Job No. 198337

Amended May 4, 2026

Re: Response to Review Comments
PUDSP255 Antelope Ridge at Bull Hill, Phase 1
Bradley Rd
El Paso County, Colorado

SHEET No. FIG-2

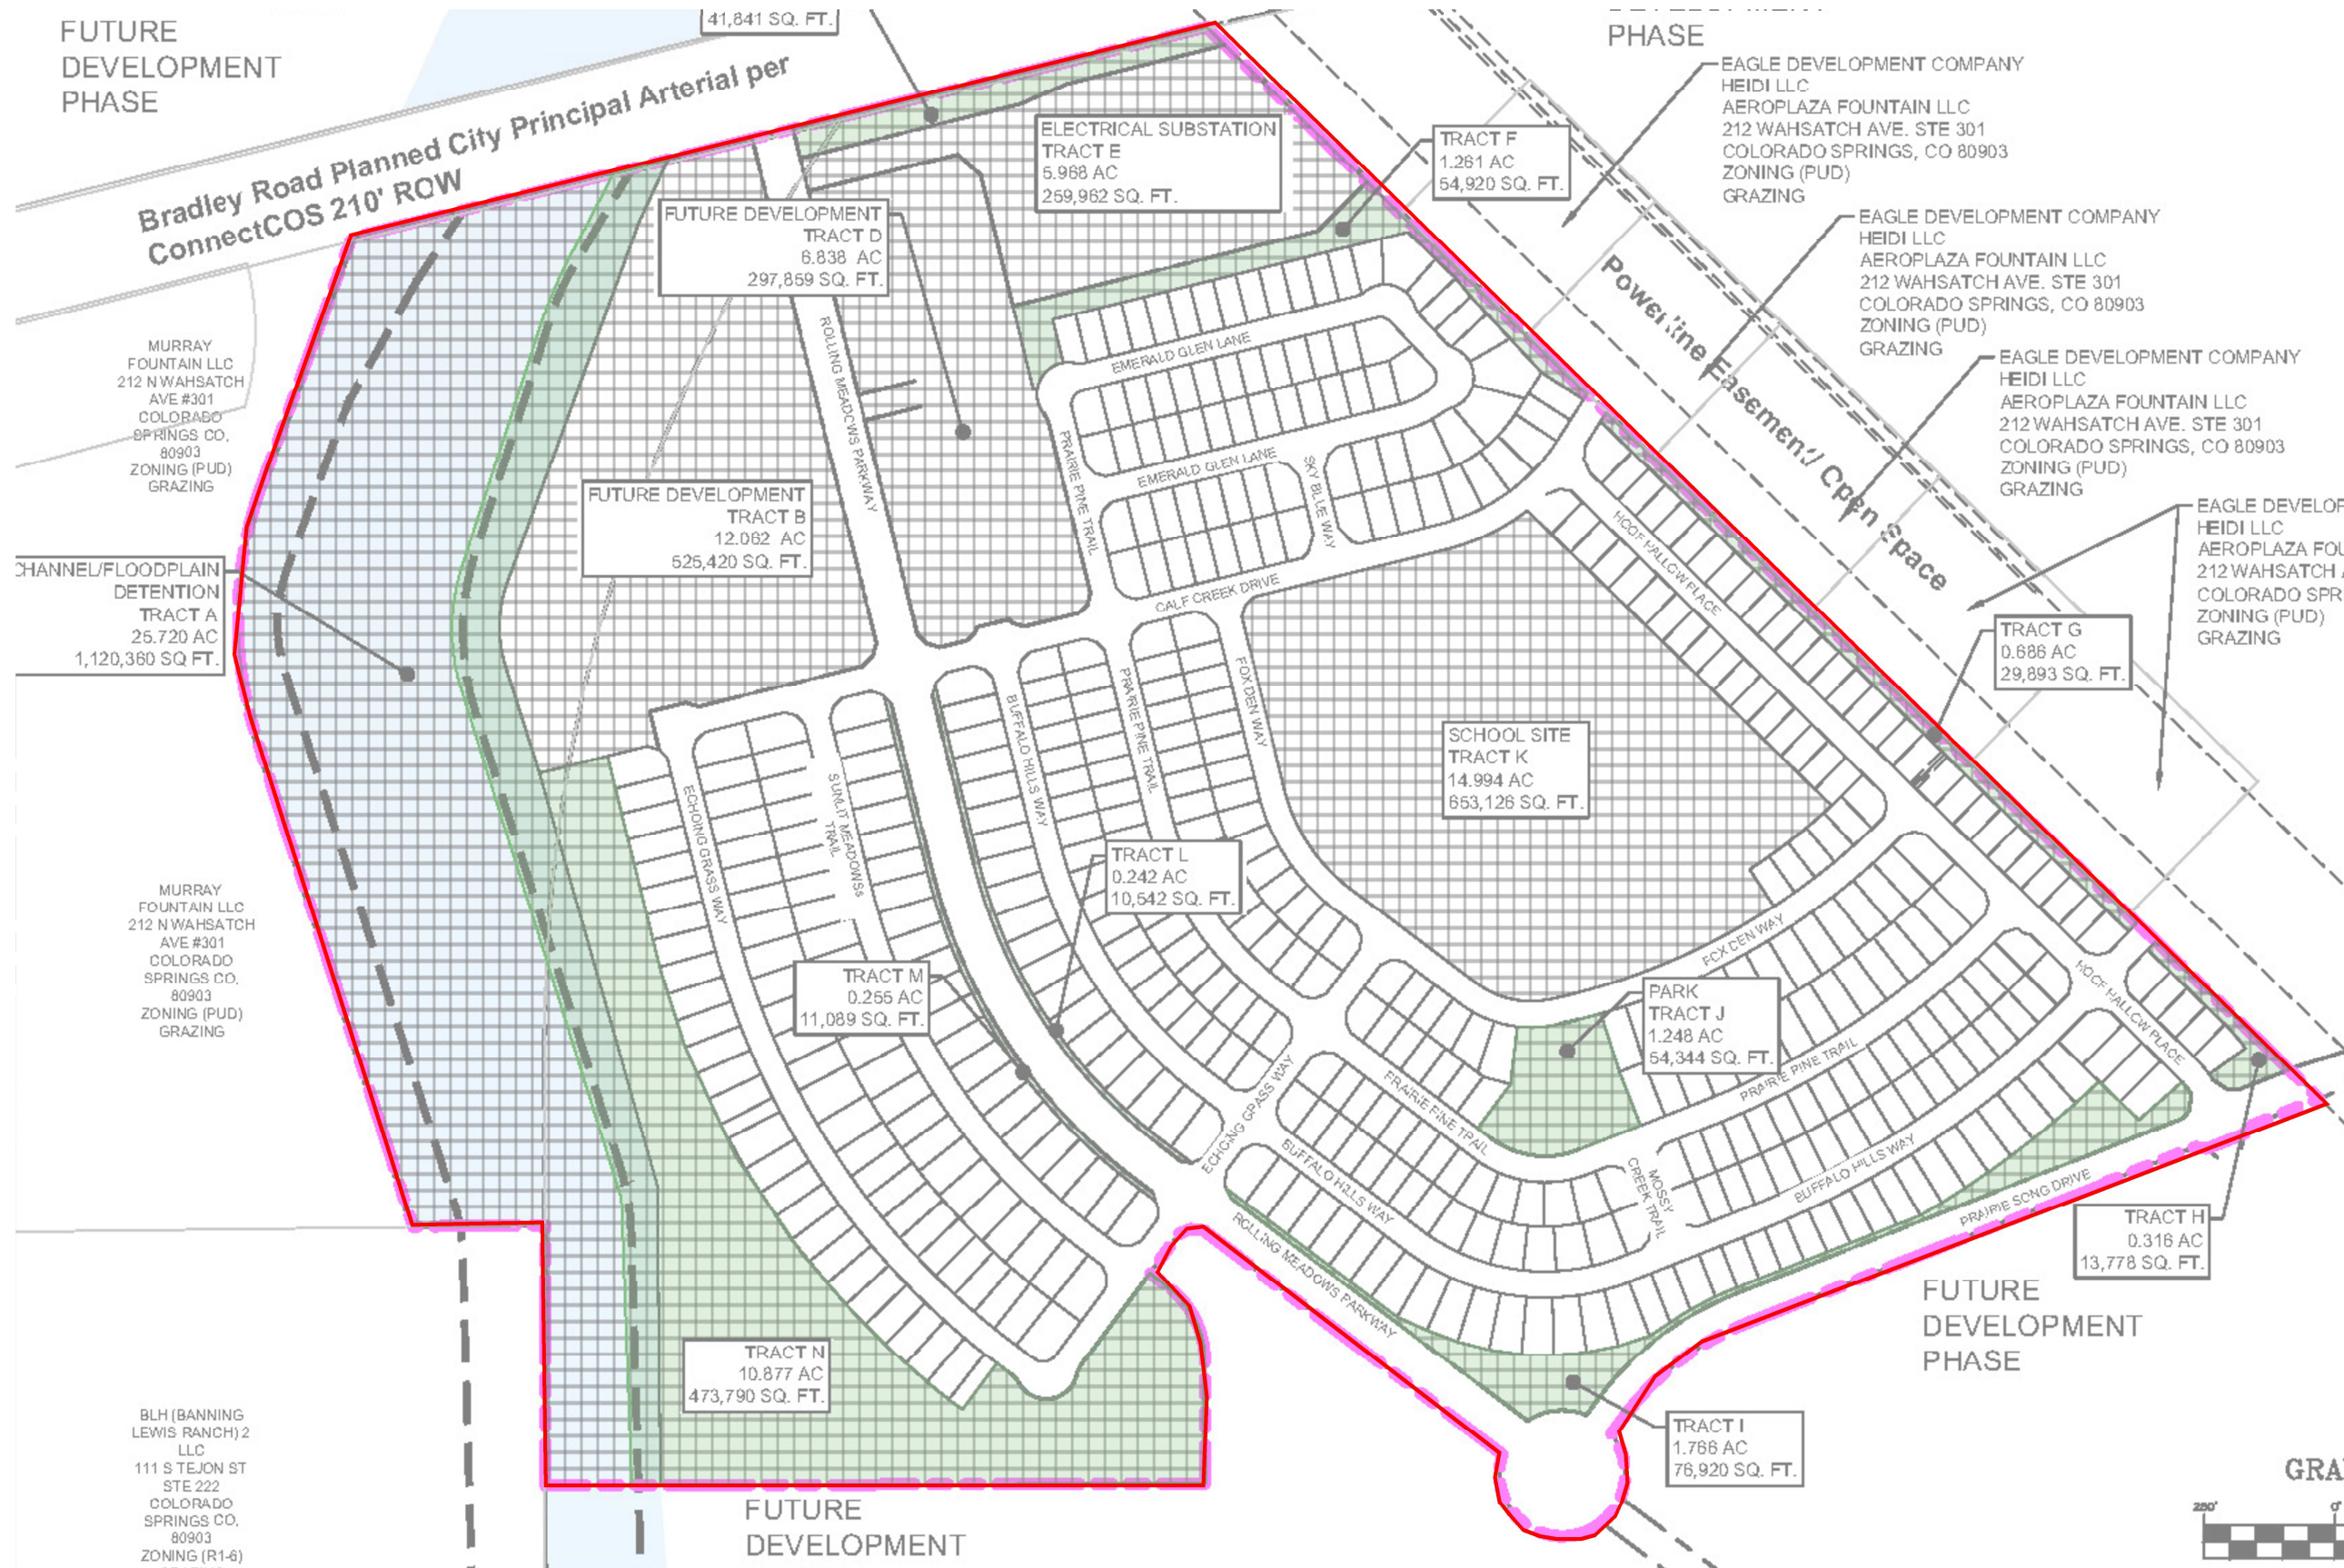
Please provide a clear figure showing all three test borings. If TB-2 is near the proposed pond, that could indicate potential for groundwater flow into the pond which would require mitigation. It is hard to tell without a figure that is clear where the borings are and the potential for this impact.

The amended report dated December 5, 2025 has been updated to reflect the additional requests. As for the comment on the location of TB-2, it is not located within a proposed pond per the Planned Unit Development provided by Matrix, last dated August 2025. TB-2 was located near Jimmy Camp Creek within the floodplain in Tract B designated for future development. A clearer Test Boring Location Plan, Figure 2 is included in the amended report.
